From: Longridge Town Council <clerk@longridge-tc.gov.uk>
Sent: 27 April 2017 18:30
To: planning
Cc: 'Lesley'
Subject: COMMENTS ON PLANNING APPLICATIONS FROM LONGRIDGE TOWN COUNCIL

Longridge Town Council would like to make the following comments:

Planning application: 3/2017/0181 Two storey side extension and single storey rear extension with a front porch at Langton House 32 Dilworth Lane Longridge PR3 3ST

SITE LAYOUT PLAN

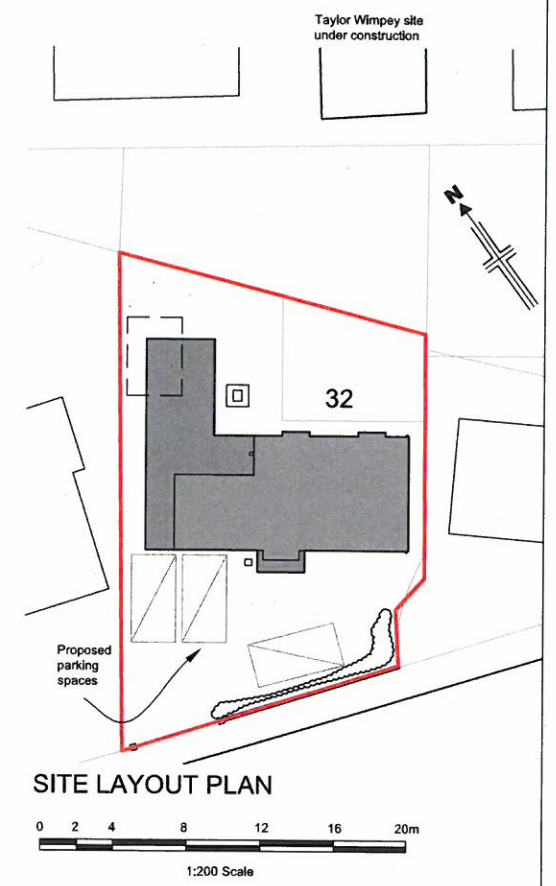
LTC - No objection in principle but would like to see the parking and turning circle facilities kept and also that neighbours are consulted.
